CITY OF ALBUQUERQUE

January 11, 2012

Re: Iden-Samora Compound Grading and Drainage Plan
Engineer's Stamp Dated 12-15-11 (G13/D028)

GRADING & DRAINAGE PLAN
LOTS A & B
IDEN-SAMORA COMPOUND

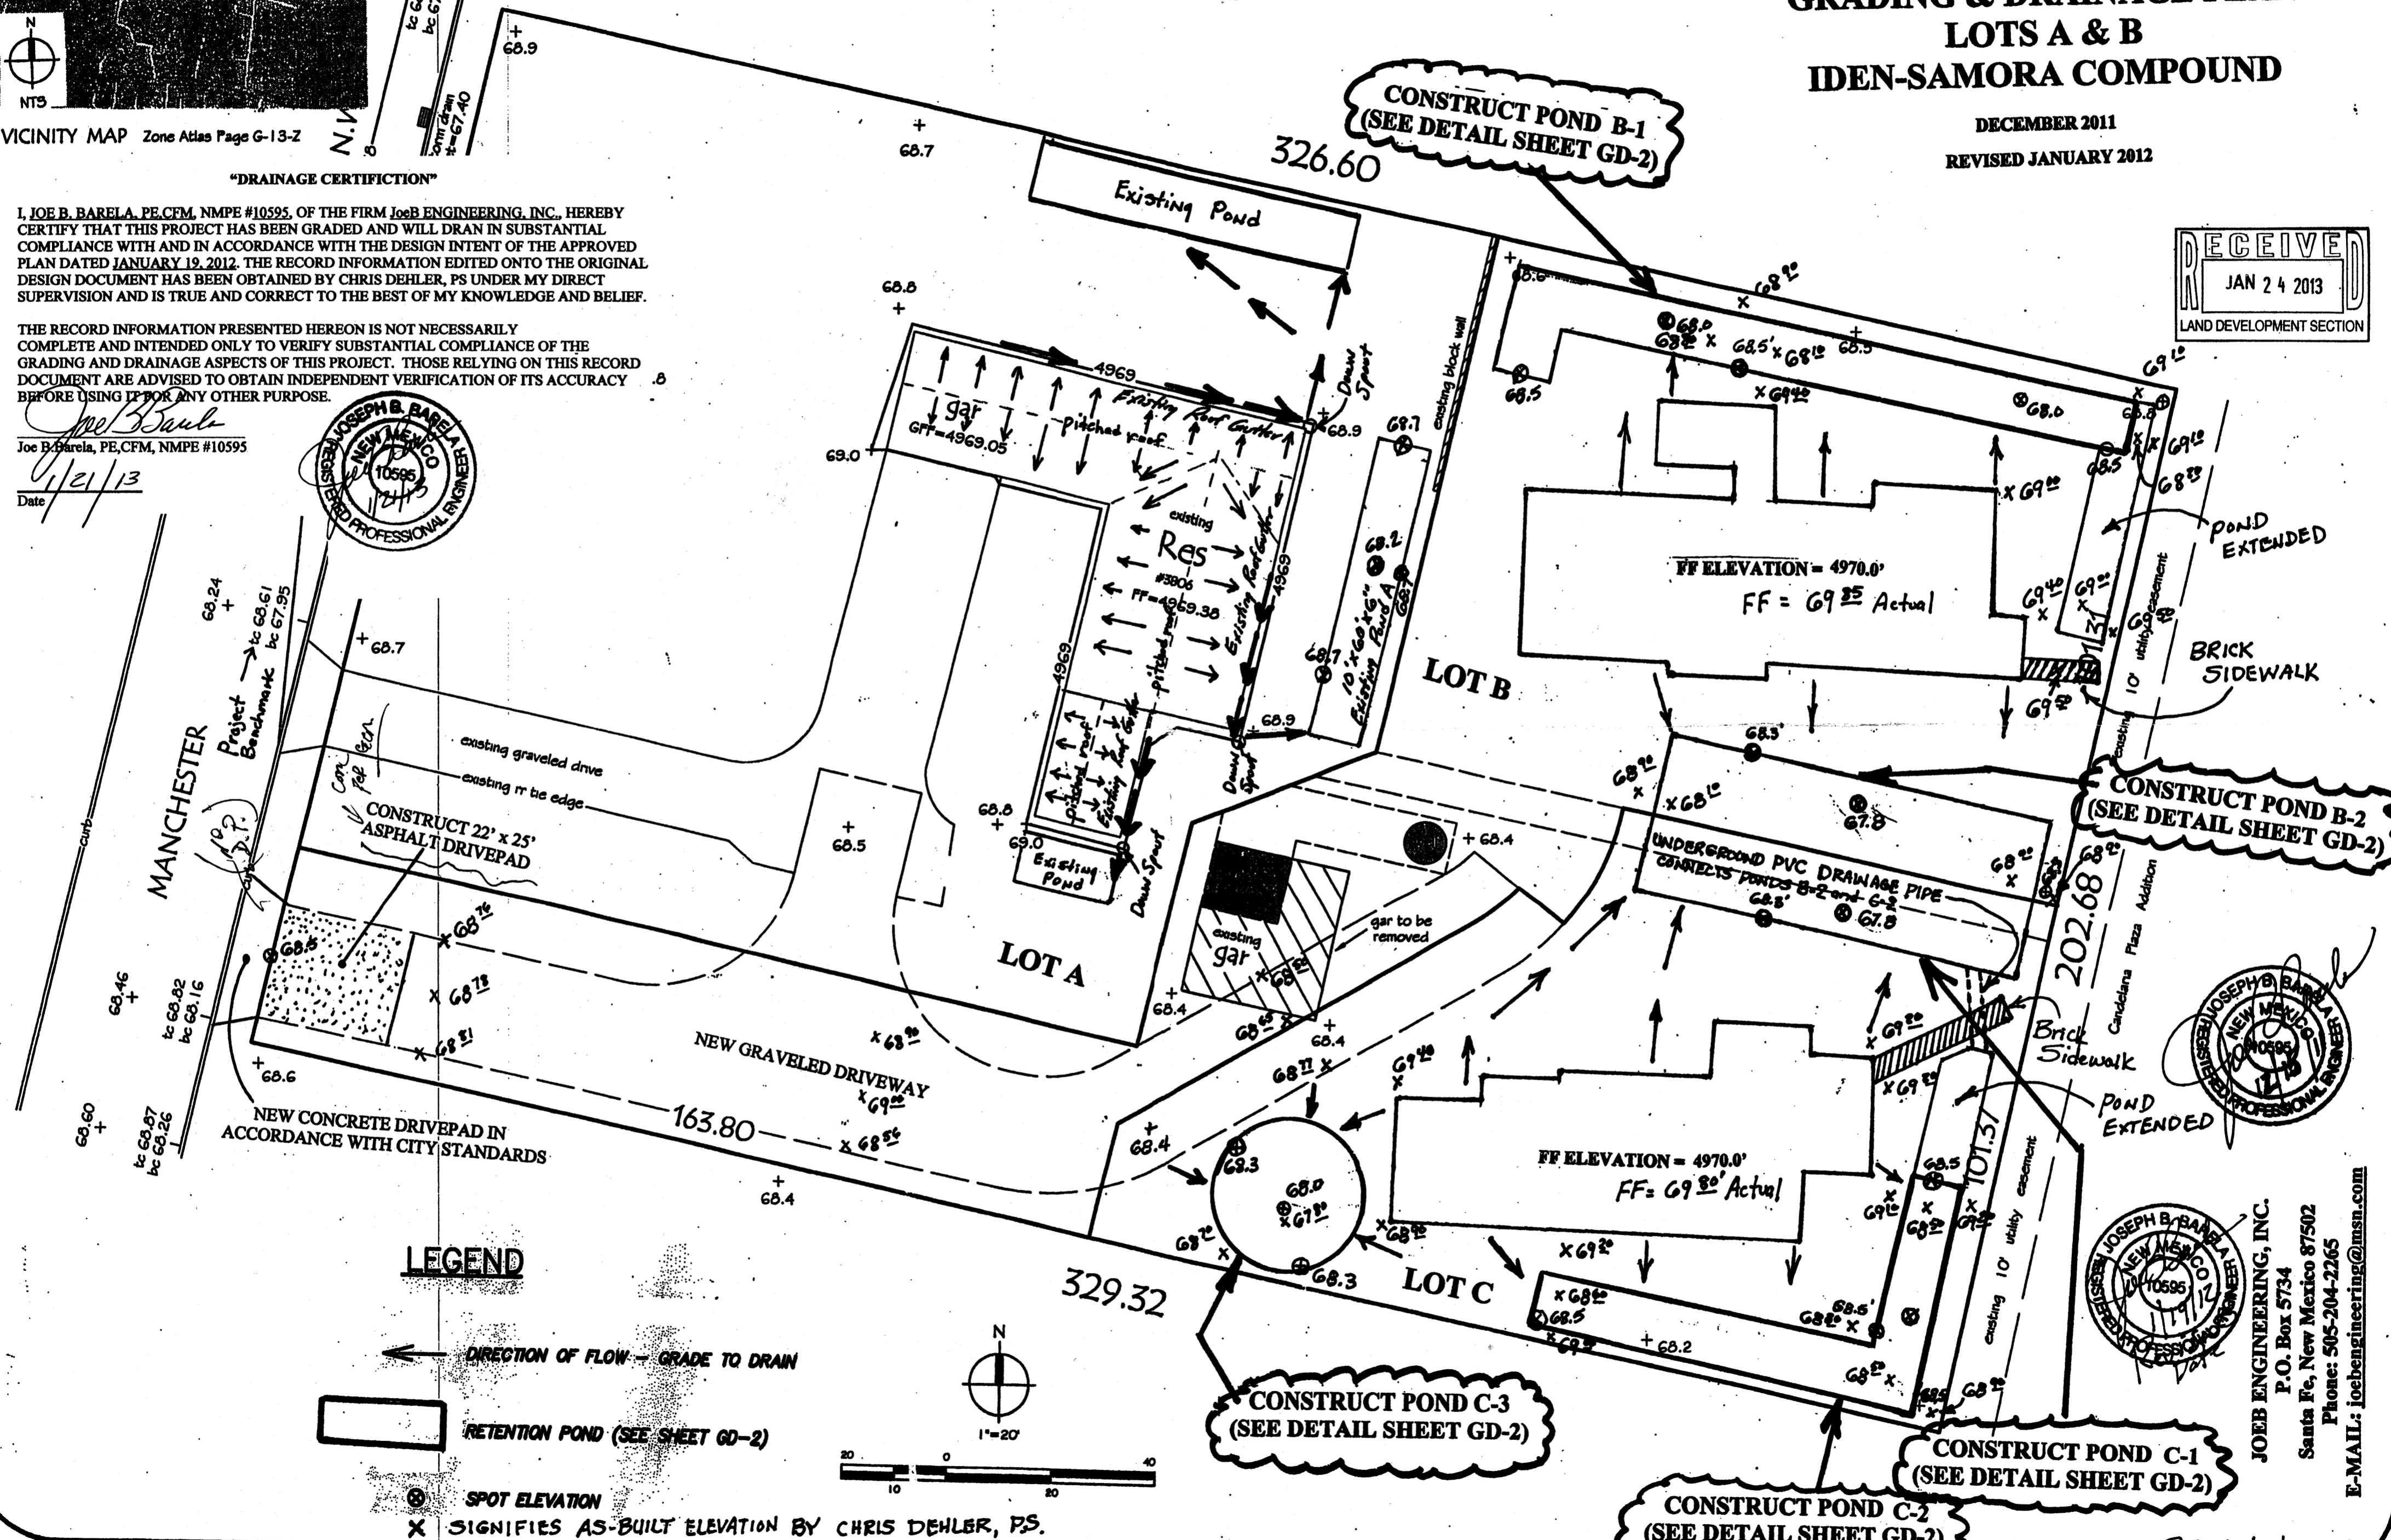
- Per the DPM, sites that use retention ponding are to retain the developed flows for the 10-day storm. Since this site is flat, currently does not have a pond, and to accommodate the development of these lots, Hydrology would agree to providing ponding for the 6-hour storm difference, as previously shown, plus the 10-day storm for proposed impervious surfaces. So, for Lot B this would be 704 cu. ft (difference) plus 507 cu. ft. (impervious 10-day) for a total of 1211 cu ft. Standard retention ponding would require 2550 cu. ft.

- ✓ • It appears that Lot A will drain to Lot B (68.9 to 68.4). This amount should be noted and accounted for. It could also be ponded on Lot A.
- ✓ • Where will the swale be built that is detailed on Sheet GD-2?

- ✓ • Show the high point/water block.
- NO • Show the proposed driveway locations. Most homeowners will not want the pond to be in the driveway.
- ✓ • Provide a couple proposed spot elevations in the landscape areas so it is easier to see the drainage path to the pond(s).

- ✓ • Provide benchmark information.
- ✓ • Provide a Vicinity Map.
- ✓ • Provide the Flood Zone designation.

JAN - 3 2012
SHEET GD-1
 HYDROLOGY
 SECTION

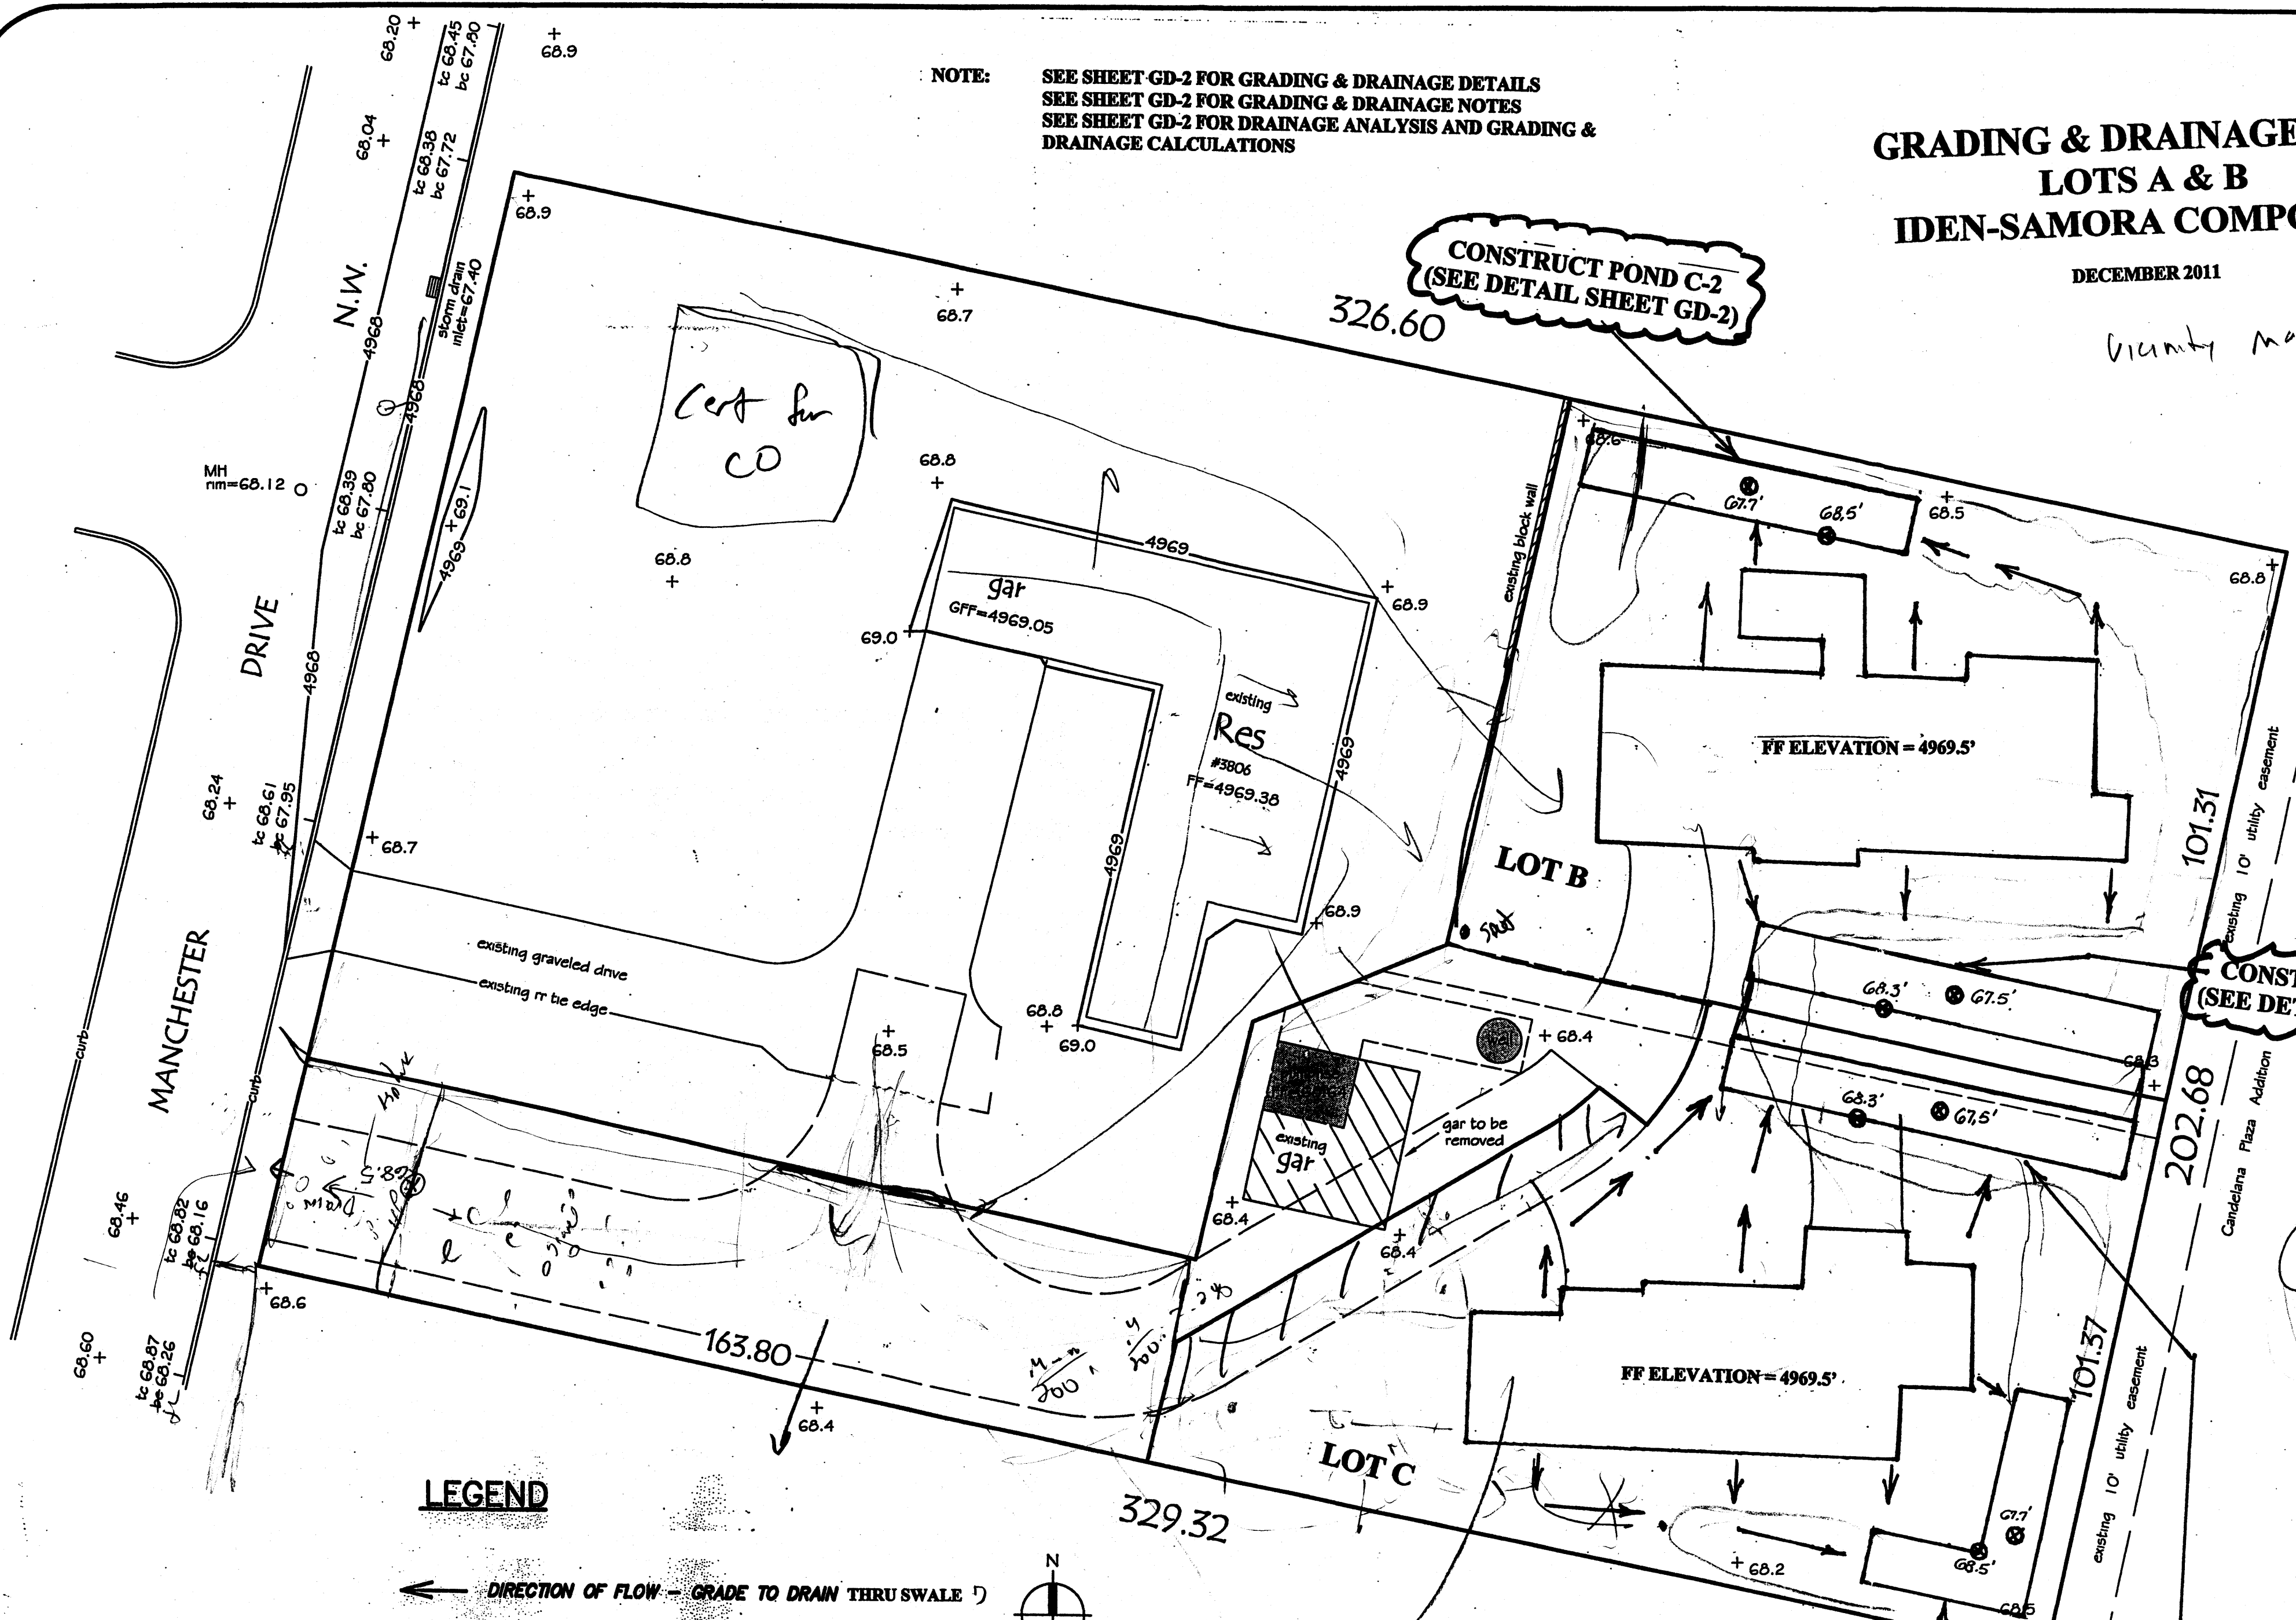
- ✓ • Provide volume calculations.
- ✓ • It seems depressing a larger area, less deep, would accomplish the necessary ponding as well as keeping the landscape areas useful.
